From: Lewis, Trevor [Trevor.Lewis@lancashire.gov.uk]
Sent: 19 December 2013 15:16
To: Stephen Kilmartin
Cc: ENV LHS Customer Service; planning
Subject: 3/2013/0902 Springfield, Whiteacre Lane Barrow

Trevor Lewis
 Traffic and Development Engineer
 Highways District Office (Pendle & Ribble Valley)
 Lancashire County Council;
 08450 530011.
www.lancashire.gov.uk.

Drawing Title
Proposed Site Plan

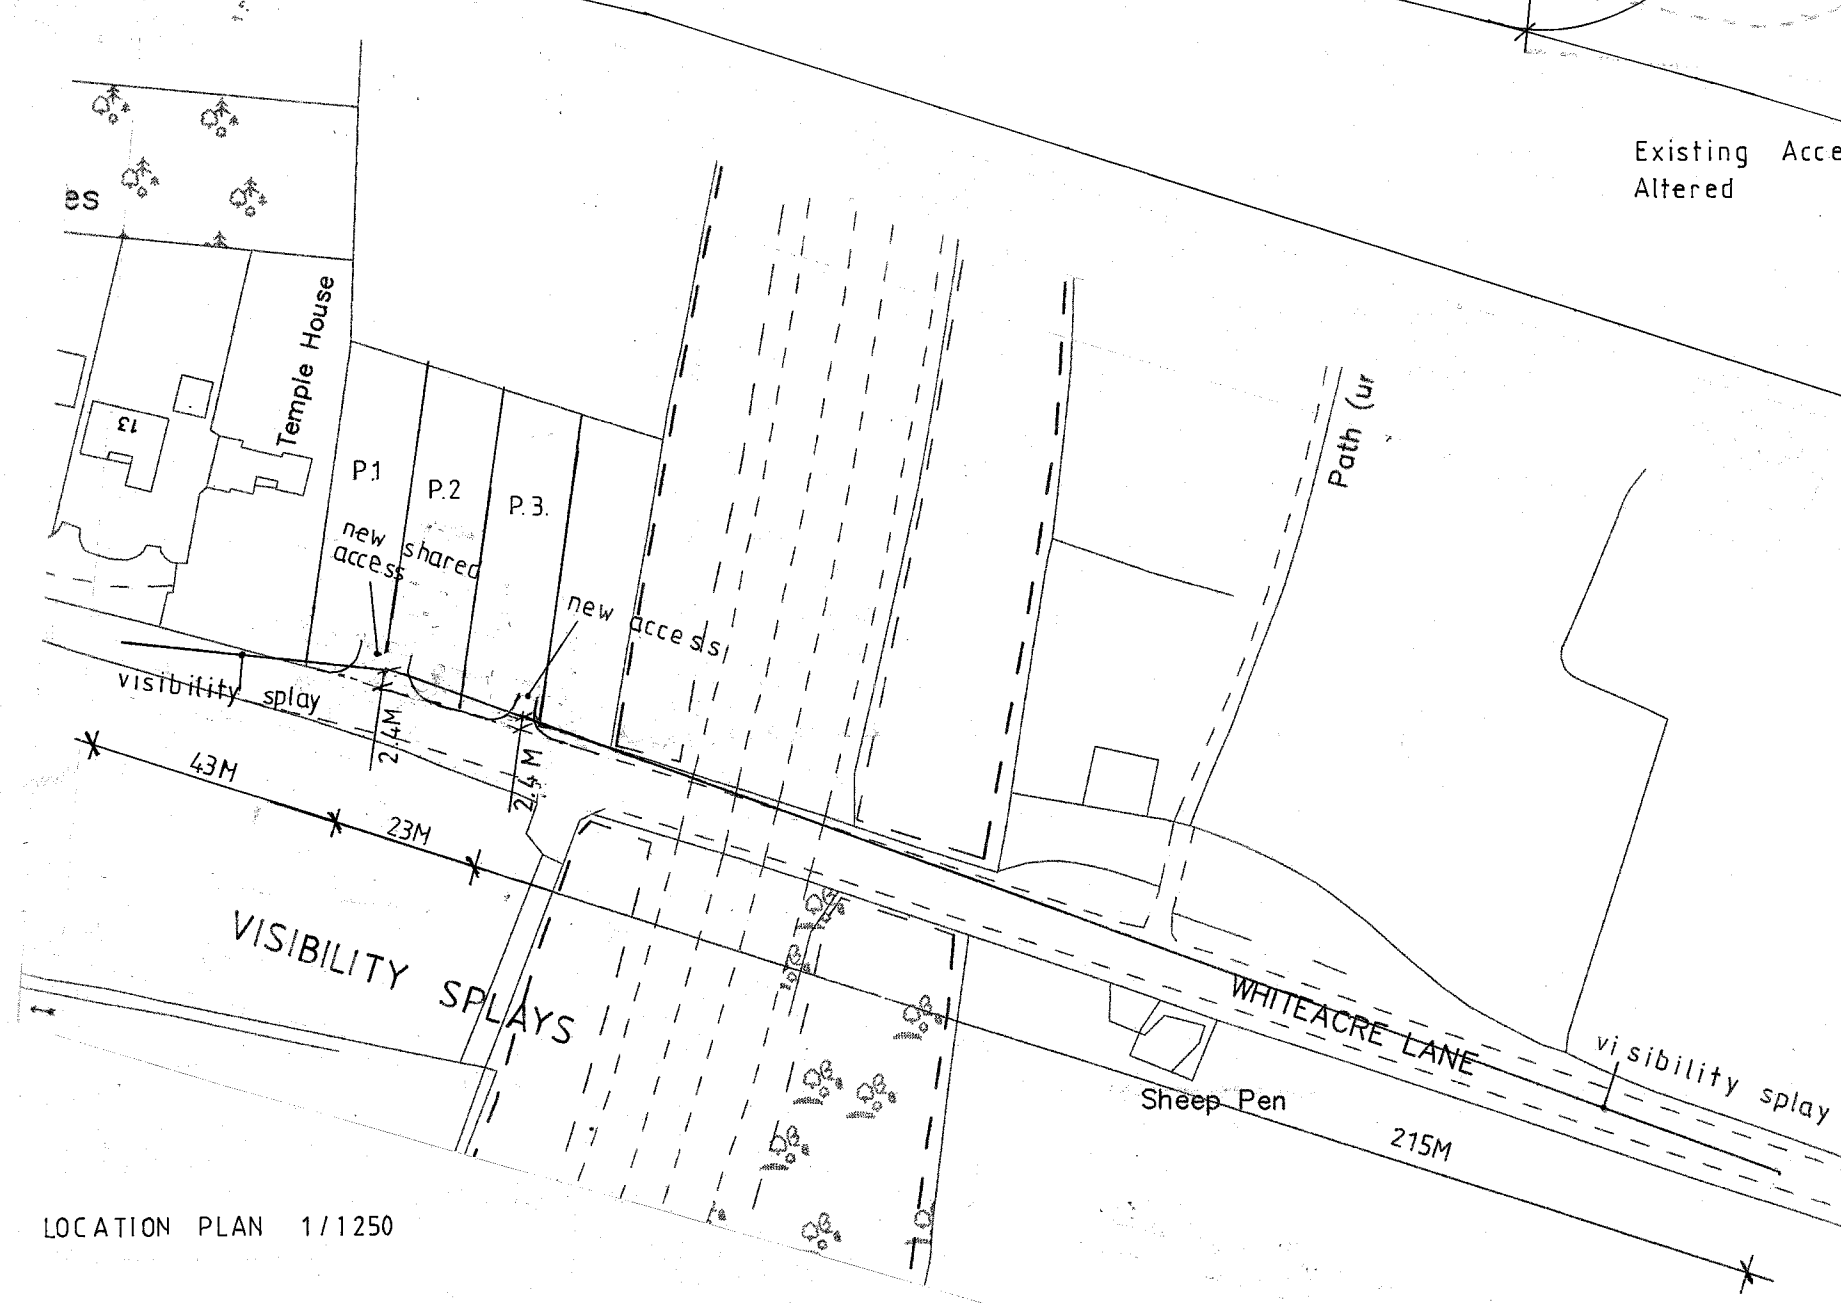
Please ask the developer to provide visibility splays of 2.4m by 43m in each direction and at each access to the three dwellings. The access to each property from Whiteacre Lane should be formed using drop kerbing rather than radius kerbs (which seems to be indicated on the drawings).

The visibility splay to be the subject of this condition shall be that land in front of a line drawn from a point 2.4m measured along the centre line of the proposed access from the continuation of the nearer edge of the carriageway of Whiteacre Lane to points measured 43m in each direction along the nearer edge of the carriageway of Whiteacre Lane, from the centre line of the access, and shall be constructed and maintained at footway/verge level in accordance with a scheme to be agreed by the Local Planning Authority in conjunction with the Highway Authority. Reason: To ensure adequate visibility at the site access.
